ST ANTHONY OF PADUA SSD -8865 - RESPONSE TO REQUESTS FOR FURTHER INFORMATION

This letter supports the Response to Submissions report (RTS) provided to you on 18 November 2019 in respect of SSDA_8865 for the proposed St Anthony of Padua Catholic School (the Proposal) at 125-165 Tenth Avenue and 140-170 Eleventh Avenue, Austral (the site).

This letter has been prepared on behalf of SCS in response to NSW Department of Planning, Industry and Environment's (DPIE) request for additional information of 9 December 2019 and further request of 29 January 2020.

PROJECT NO.	4032	DRAWING NO.	DA005	REVISION	15
-------------	------	-------------	-------	----------	----

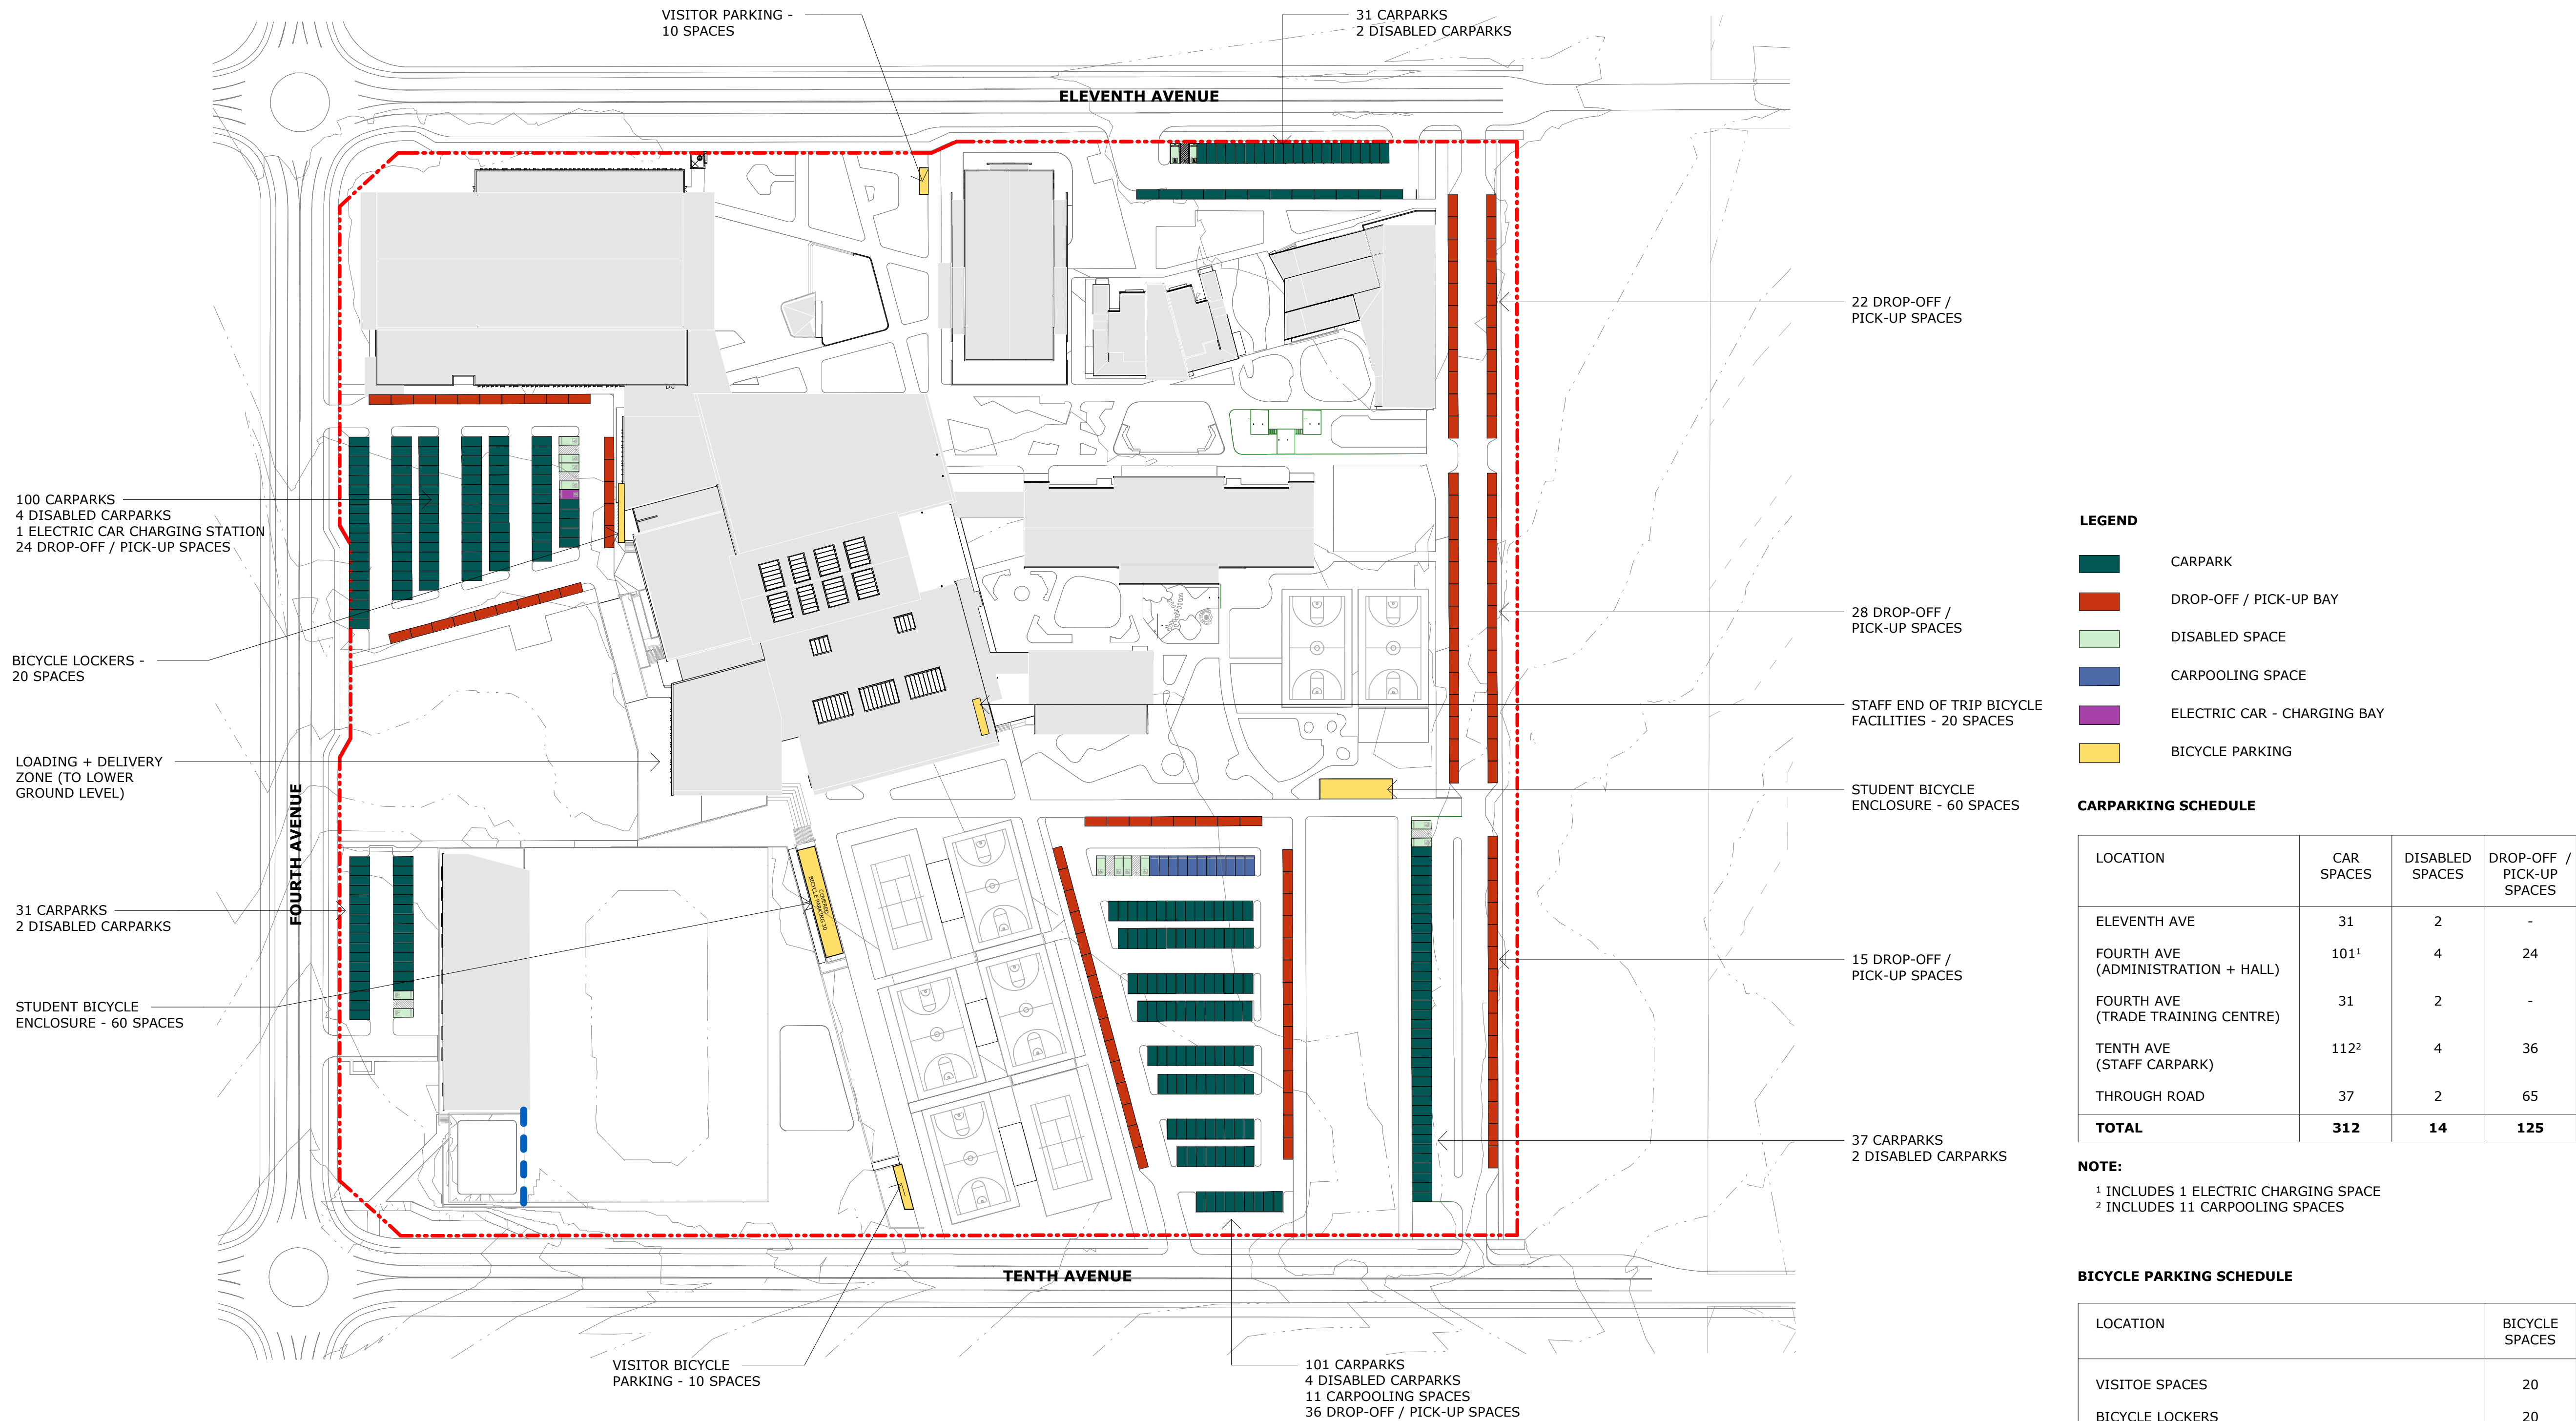
10.5 the 'Site Plan – Detailed Proposal' (DA005)	DA005 has been updated as requested. All structures are	Attachment A-

Matter	Response	Refer to
<p>should be updated to identify both the existing and proposed boundaries, consistent with all other plans. The Site plan must demonstrate that all structures, including the roof of the Indoor Recreation Centre and any perimeter fencing (including fencing on Tenth Avenue) are to be located wholly within the new boundaries of the site.</p>	<p>within the perimeter of the site.</p>	<p>Architectural Plans – DA005_R15</p>
11 Sydney Water comments		
<p>11.1 Additional information should be submitted responding to the comments from Sydney Water, provided during the EIS exhibition.</p>	<p>Consultation between the applicant and Sydney Water has been ongoing since the lodgement of the EIS. Sydney Water issued an updated Notice of requirements (NOR) on 30 July 2019. The applicant is addressing the updated NOR. Sydney Water has confirmed that this NOR supercedes any previous comments made on the exhibited EIS. The NOR and Sydney Water correspondence have been included at Attachment F.</p>	<p>Attachment F – Sydney Water NOR</p>
